Recommendation Report for Planning Permission for Works or Extension to a Dwelling

REF NO: AB/87/13/

LOCATION: 19A River Road
Arundel

PROPOSAL: Balcony extension on rear elevation (resubmission following AB/43/13/). This application affects the character and appearance of the Arundel Conservation Area.

Proposed balcony extension

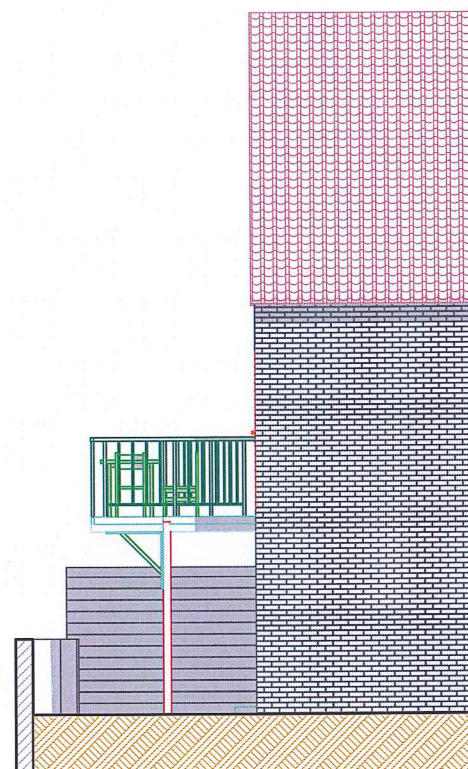
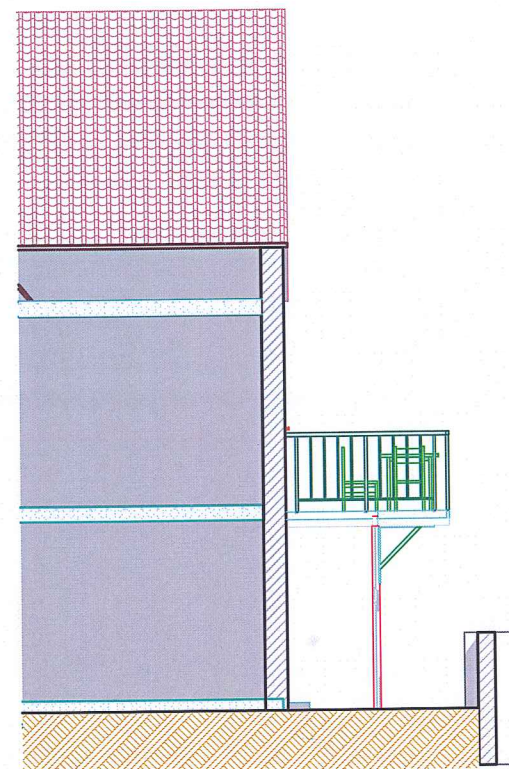
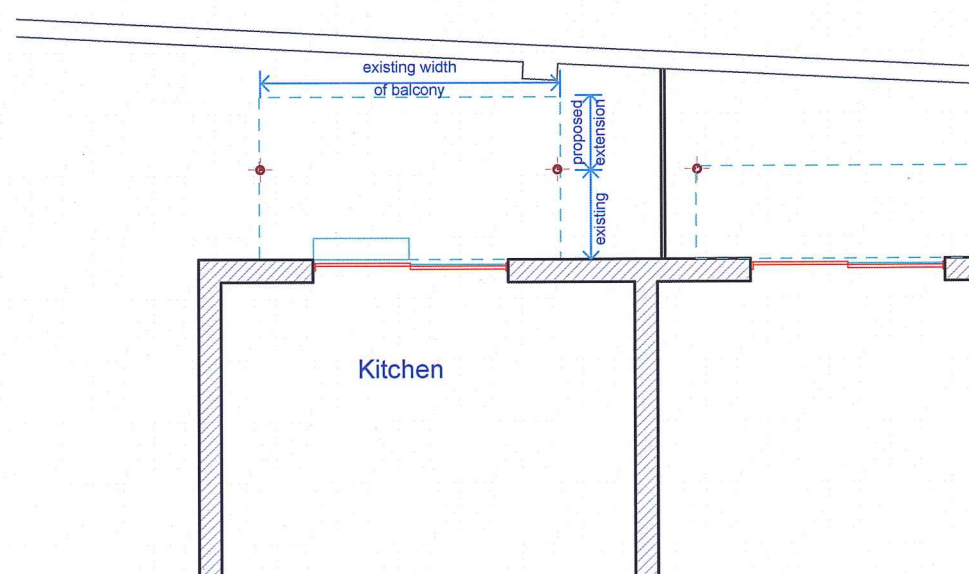
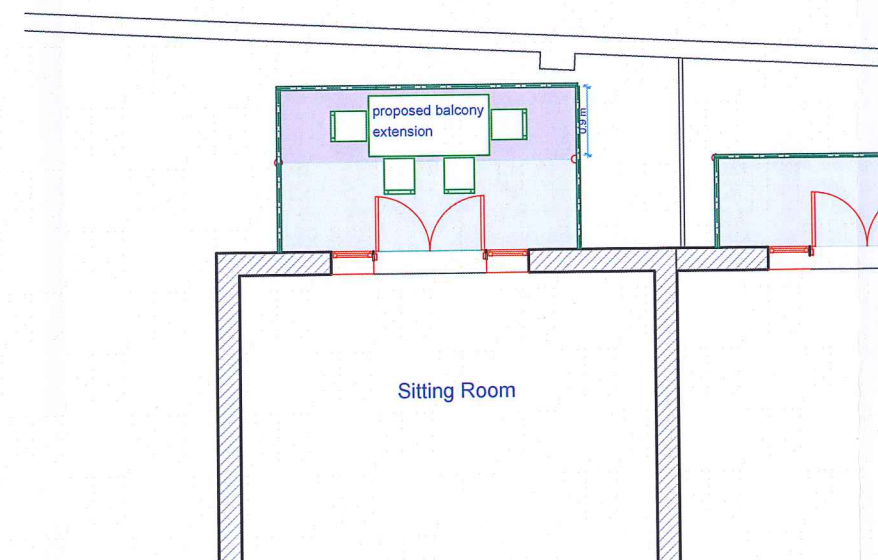
Privacy. Existing balconies only provide views up and down the river and do not allow a line of sight into next door rooms, unlike the proposal.

Appearance. The balcony extension will change the appearance of the terrace row. They were constructed to give unity of design and appearance. The size of the extended balcony will break this unity.

There will also be extra weight which could affect the stability of the earth fill-in below the terrace and river wall.

This application seeks to extend an existing rear balcony at first floor level to an increased depth of 0.9m. This end of terrace property exhibits strong design uniformity with the two other neighbouring properties in the row (19B and 19C to the west) at both the front and rear. Therefore, it is considered important that any changes to the appearance of the property does not deviate to the detriment of the character and appearance of these neighbouring properties and the surrounding Conservation Area. Upon consideration, the balcony extension does respect the style and materials of other balconies in this terrace row and therefore is considered to meet this requirement. Also, the proposed railings will be ironwork to match existing and as such are considered to be acceptable in design. This will be a design improvement on previous submission

Since all dimensions of the balcony extension will match existing apart from its depth, this is the only aspect to consider in terms of residential amenity. The increase in its depth is not considered to be significant and will bring the balcony closer to the rear boundary and the river. However, any overlooking caused by this increase on to the neighbouring property of 19B will not be direct given the reasonable separation distance between the balconies and the resulting low angle generated by the extension. It is therefore considered to not cause any unacceptable overlooking or loss of privacy on this or any other property and so is considered to comply with Local Plan policy DEV19(iii).

In response to the letter of objection, the privacy and appearance issues raised are addressed in the Conclusions section of this report. The stability of the earth fill-in as a result of this proposal is not a material planning consideration.

- 3 The materials and finishes of the iron railings hereby permitted shall match in colour and texture to those existing.
